# CITY OF ALBUQUERQUE

**Re: Maverik – Comanche Princeton**  
**3737 Princeton Dr. NE 87107**  
**Traffic Circulation Layout**  
Engineer's/Architect's Stamp **10-28-18** (G16D029)

Based upon the information provided in your submittal received 10-28-18, the above referenced plan cannot be approved for Building Permit until the following comments are addressed:

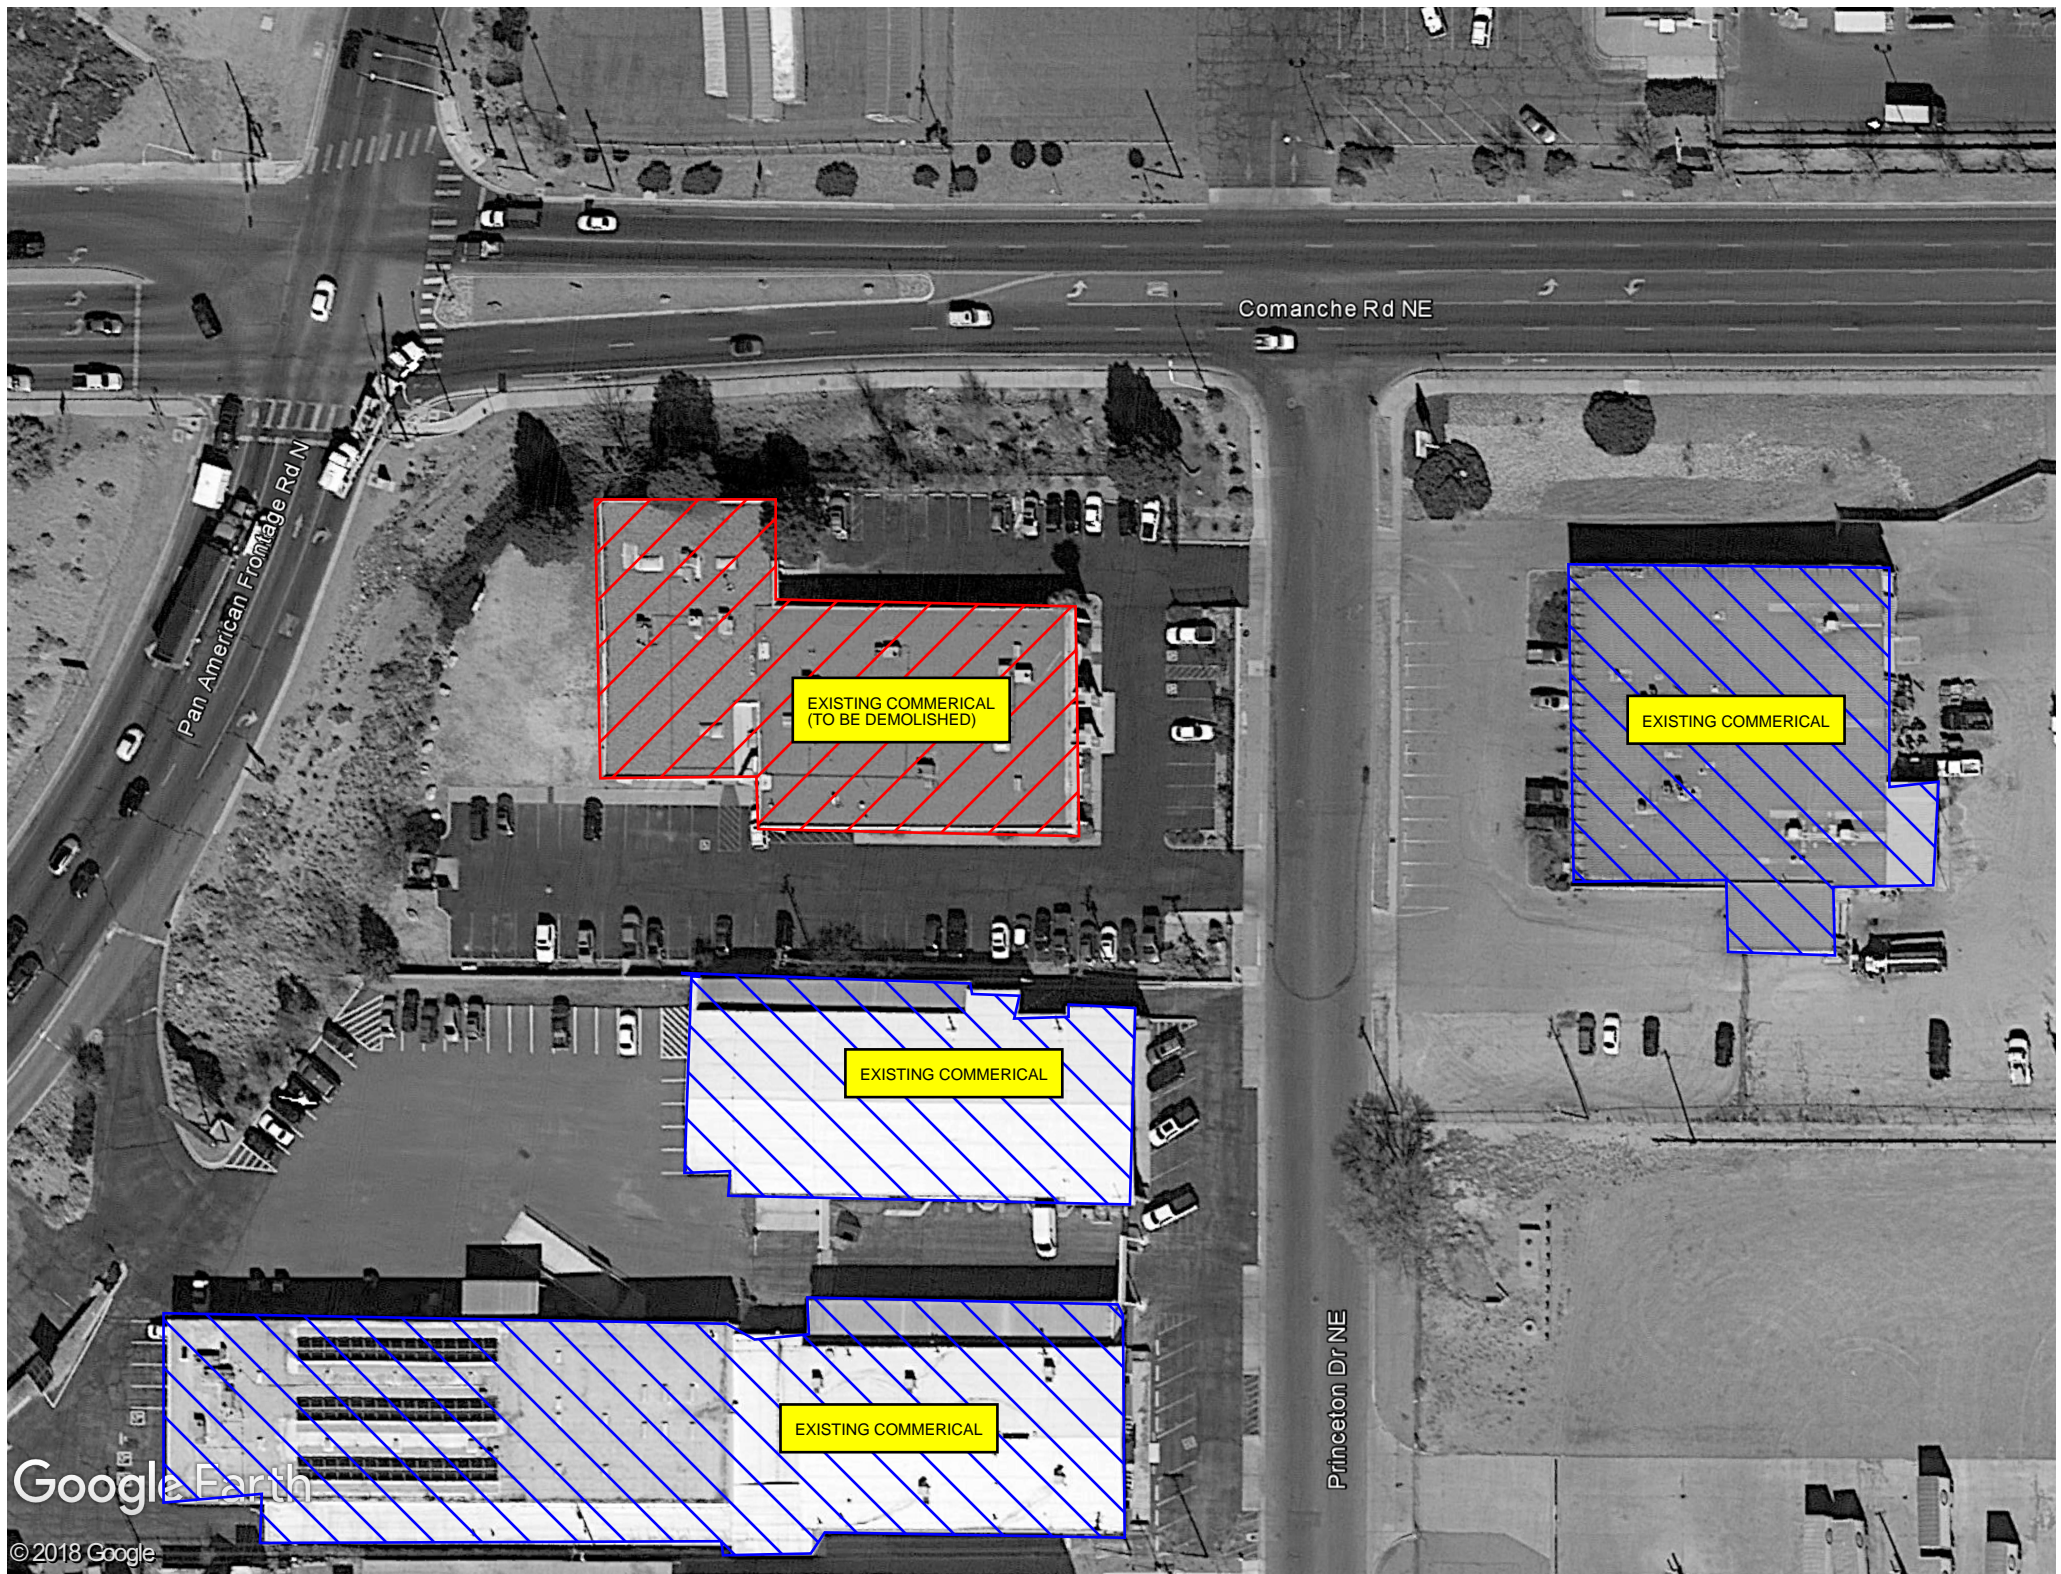
1. The ADA access aisles shall have the words **"NO PARKING"** in capital letters, each of which shall be at least one foot high and at least two inches wide, placed at the rear of the parking space so as to be close to where an adjacent vehicle's rear tire would be placed. (66-1-4.1.B NMSA 1978)
2. Motorcycle parking spaces shall be designated by its own conspicuously posted upright sign, either free-standing or wall mounted per the zoning code.
3. An Approved TIS from both COA and NM-DOT is required before TCL approval.
4. The maximum width of the access entry should be 35'.
5. Please provide the distance from the intersection for the North entrance.
6. Please provide the distance from the property line for the south entrance.
7. Refer to the picture below :

Please change the radius in a way that the curb stays with the frontage line.
